PLANNING DEPARTMENT
DEVELOPMENT SERVICES DIVISION
600 2nd Street NW, Ground Floor, 87102
P.O. Box 1293, Albuquerque, NM 87103
Office (505) 924-3946

OFFICIAL NOTIFICATION OF DECISION

Project# PR-2020-003847
Application#
SI-2021-01955 SITE PLAN

SDP1.1

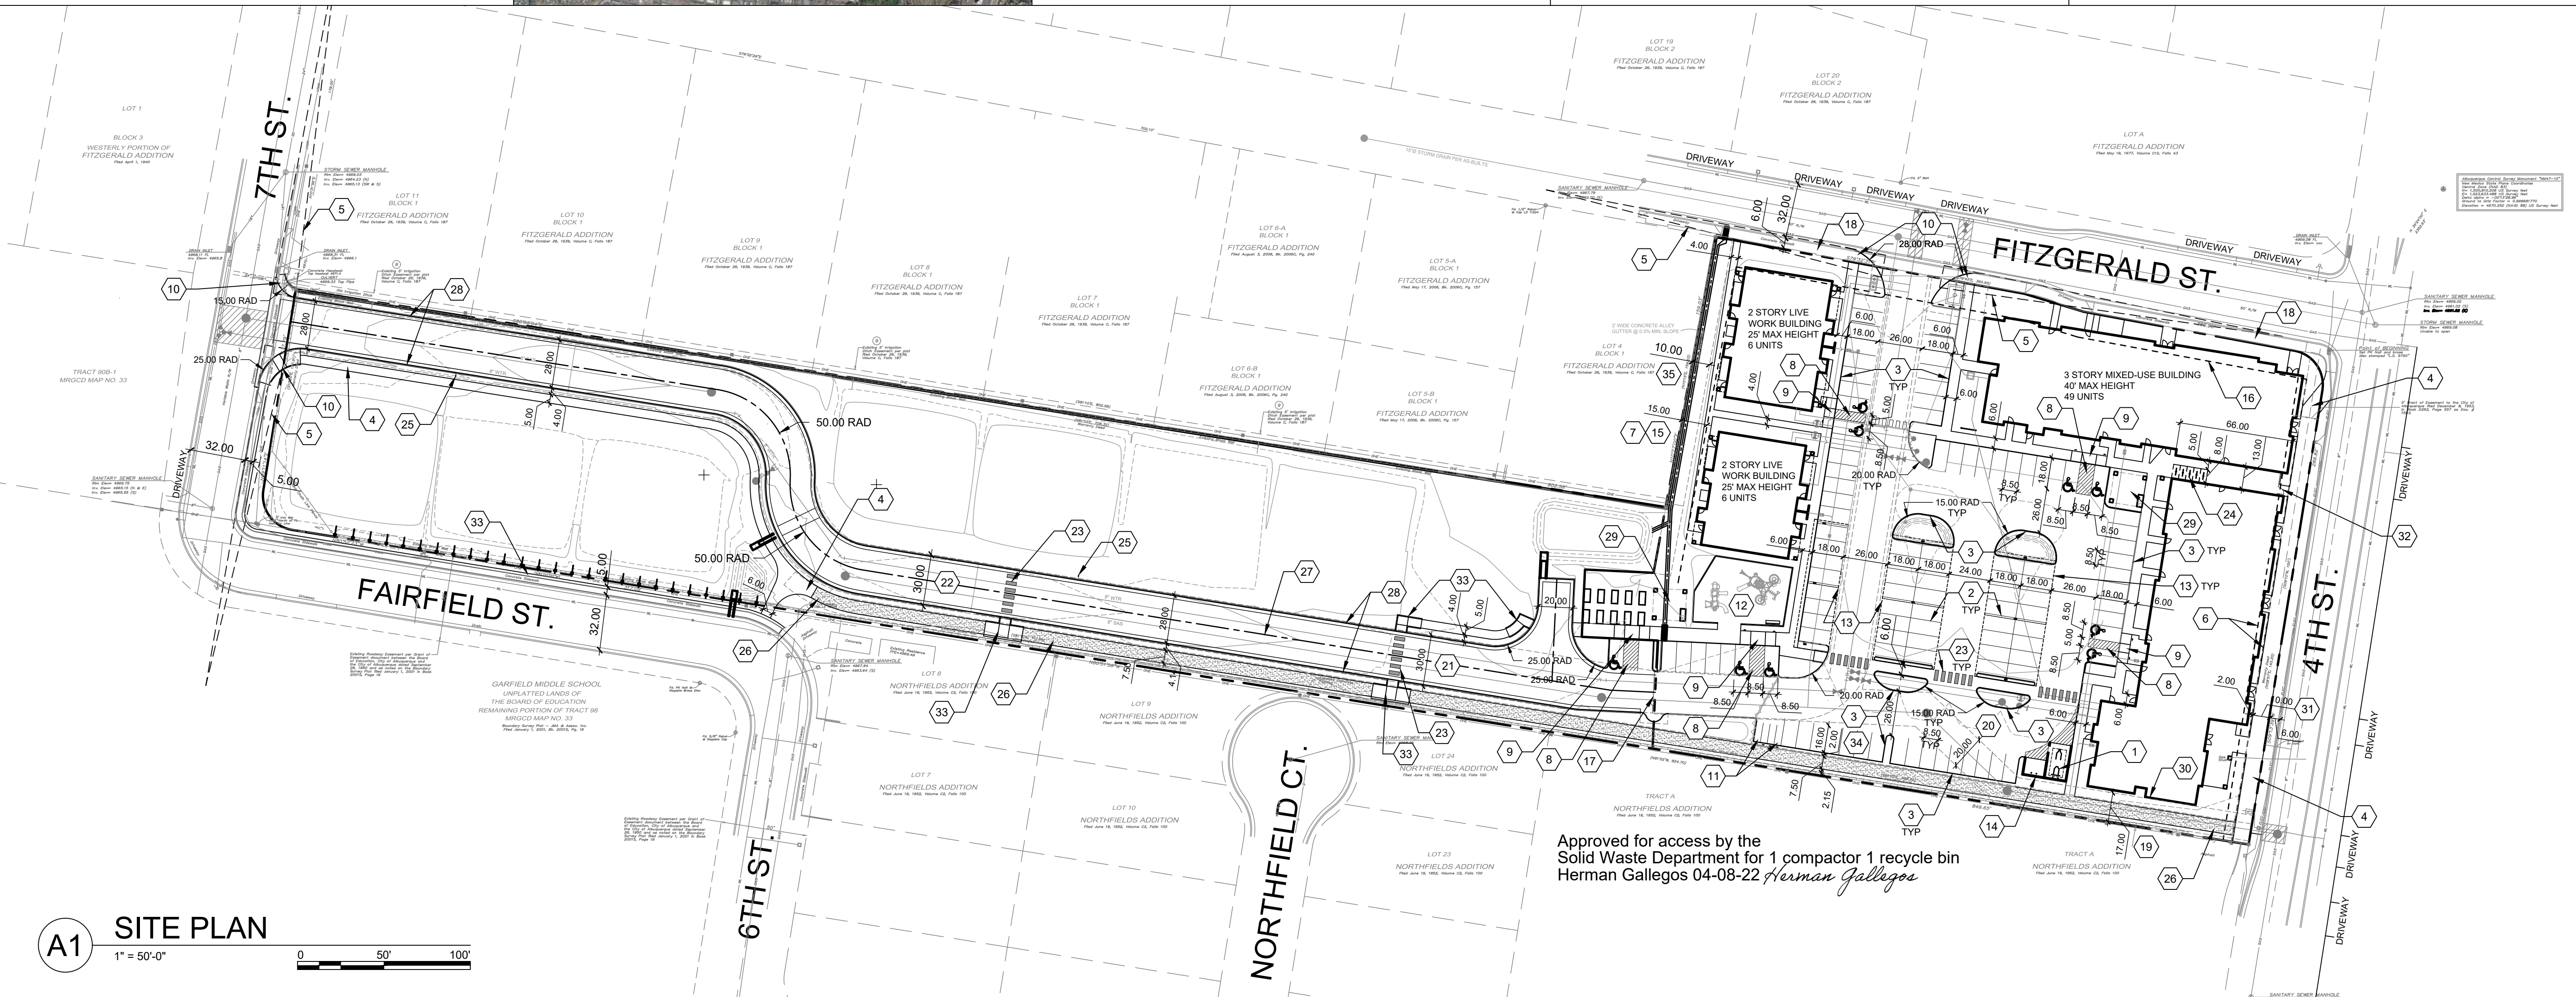
- 1. This Site Plan is valid 7 years from DRB approval (1/26/2022). An extension may be requested prior to the expiration date.
- 2. Final sign off is delegated to Transportation for the revision of the Plat (SD-2021-00219) to clarify the details of the shared access way to include all elements of the Site Plan as well as the addition of the sidewalk easement with the revision of the sidewalk moving along 4th Street; the redesign of the road and sidewalk accessed from Fitzgerald as stated by Parks and Recreation; the clarification of work order items; minor labeling and labeling of all pedestrian ways, dimensioning as stated, labeling of overhang for the 16-foot parking spaces, and labeling of curbed and paved surfaces.

- 3. Final sign off is delegated to Planning to update the Utility Plan to the version distributed to ABCWUA on January 19, 2022 and as emailed January 26, 2022; the inclusion of a required note specifying that the southernmost building footer shall be designed such as the adjacent sewer main can be maintained without dividing the footer on behalf of ABCWUA; revise the material of the walkway from gravel to stabilized crusher fine; clarify the planting of vines along the southern edge of the property by either enlarging the symbol or adding a detail; eliminate the tree at the northeast corner of the Landscape Plan and chamfer the sidewalk corners of the sidewalk to provide an easier transition on behalf of Parks and Recreation; a recorded IIA; a note be added to the Landscape Plan as follows: "Drainage pond to be stabilized per COA Interim guidelines for drainage pond seeding and slope stabilization (Section 1013) or per a future landscape plan that provides equivalent and better outcome for stabilization, maintenance and aesthetic quality;" Solid Waste signature; the north and south facades be re-checked and re-designed as needed to be compliant with the IDO; add north elevations for Buildings 2 and 3; detail how the façade design requirements for Buildings 2 and 3 are met; confirm that the windows on the upper floors are recessed at least 2 inches; and confirm that a minimum of 30% of the surface is transparent windows or doors.
